Our Ref: A/03669

27th January 2026

Arena Young Peoples Centre, Moorlands Road, Dewsbury, WF13 2LF - (KIRK) - Erection of 10-unit (class C2) special needs care home, day centre (class E(f), administration and training building (class E(g)(i)

Drawn	OG	Chkd	PB	Date	June 2025	Scale	As Shown @A1
Contract No.	25156	Drig No.	DR-C-0100	Revision			P1

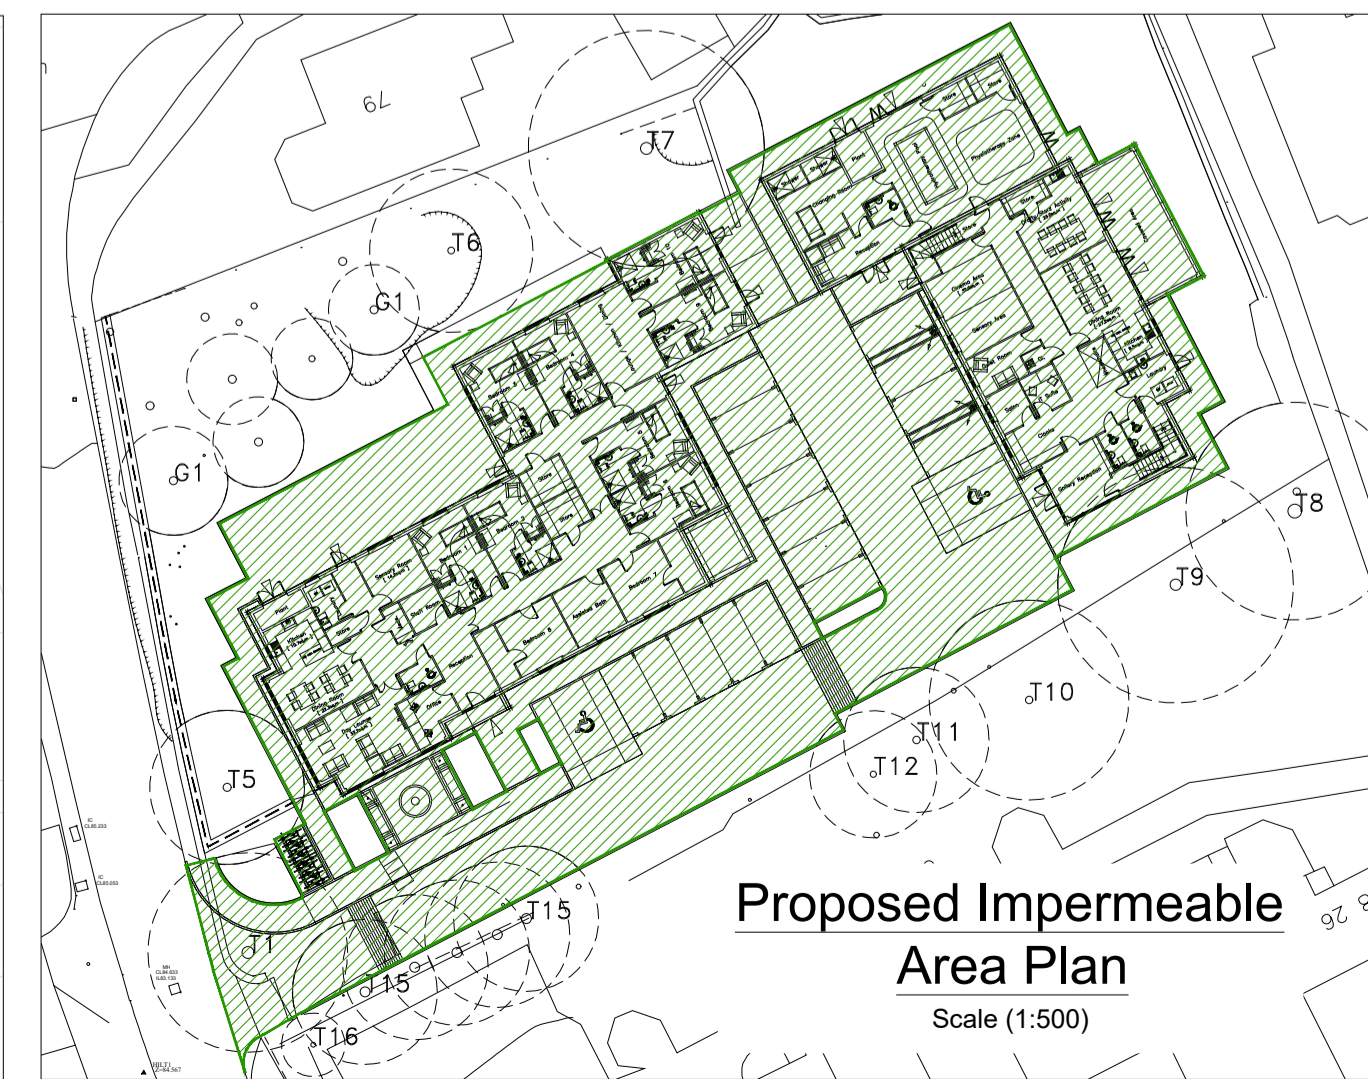
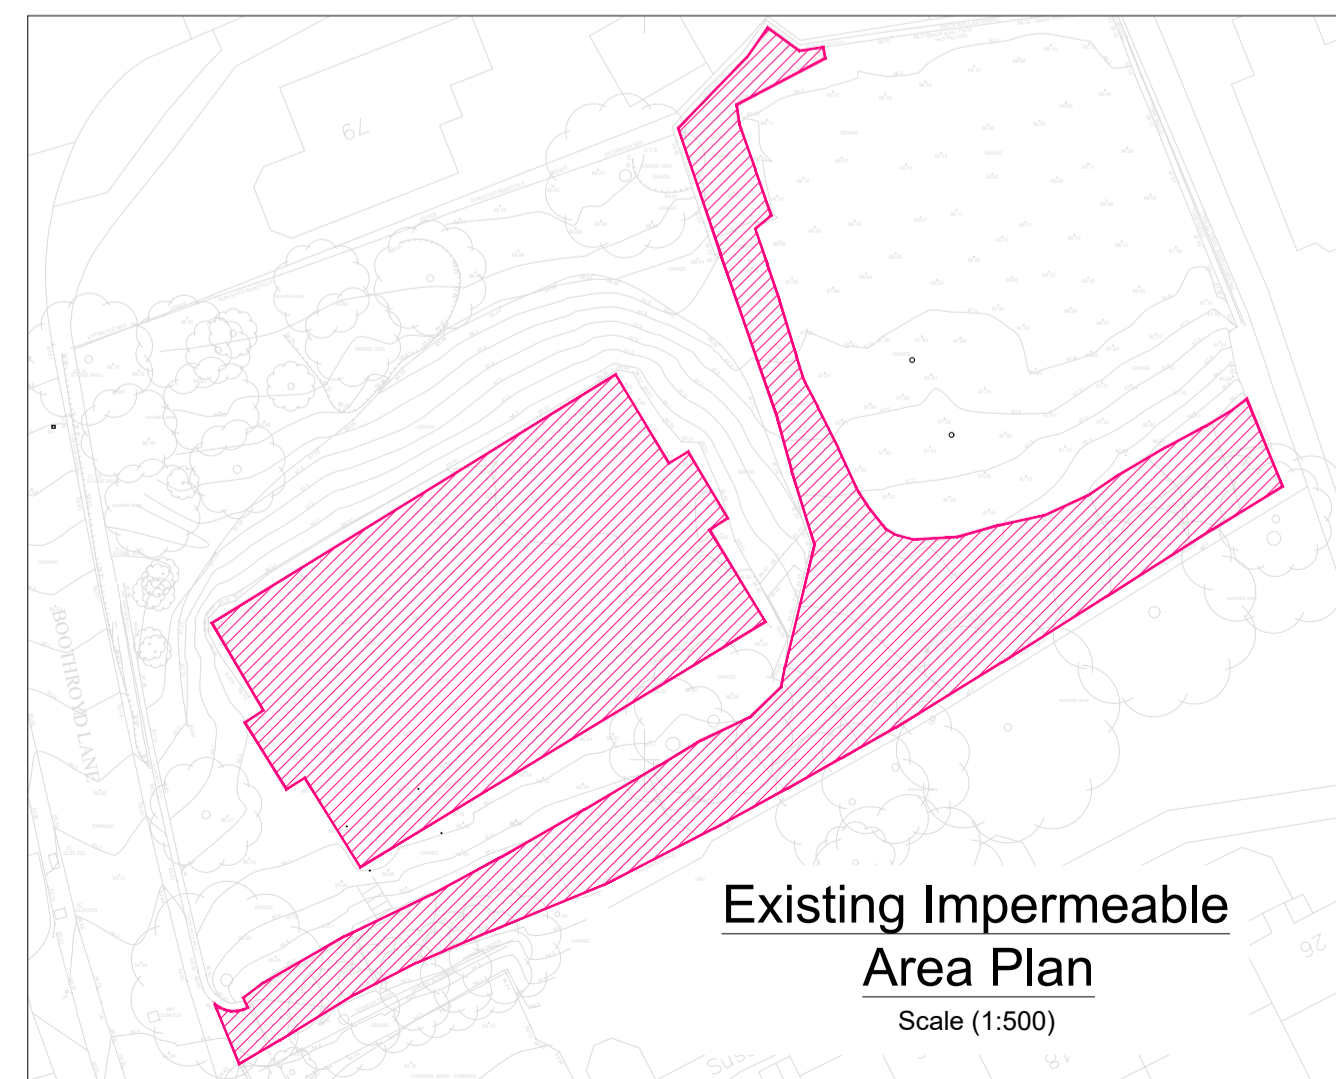
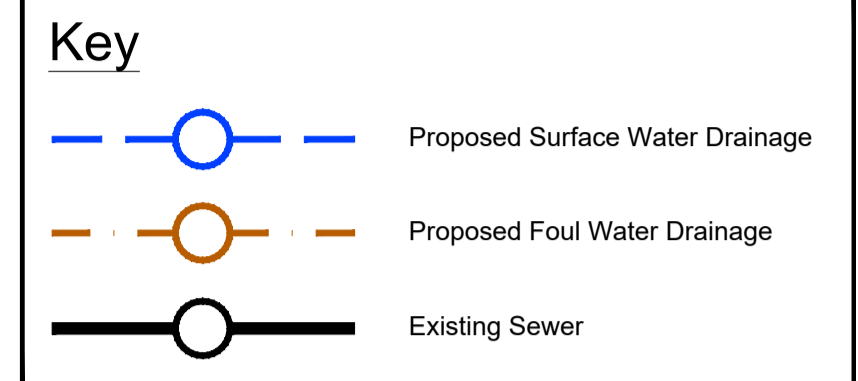
1) The drainage details submitted on drawing DR-C-0100 (revision P1) dated 19/06/2025 that has been prepared by Topping Engineers require amendments. The following point should be addressed:

a) evidence of existing impermeable areas positively draining to the public sewer is required to prove rate of discharge

2) If other methods of surface water disposal are not viable, curtilage surface water discharges to the public sewer will be restricted to the level of run-off - i.e. same rate of discharge - to that from the existing use of the site less a 30% reduction in the existing discharge. Any discharge of surface water from the site should discharge to similar points of connection to that of the existing use of the site. You will need to demonstrate positive drainage, based on a 1 in 1 year storm, to the public sewer to Yorkshire Water by means of investigation and calculation carried out at your expense.

a) To do this, Yorkshire Water requires to see existing drainage layouts with pipe sizes, gradients, gullies, downpipes and connection points, measured impermeable areas of the present use of the site, along with the calculations that show the existing discharge rate from the site to the public sewer.

- 3) Failing this, the surface water discharge from the proposal may discharge to the public surface water sewer in Boothroyd Lane, the discharge must be restricted so as not to exceed 3.5 (three point five) litres per second.
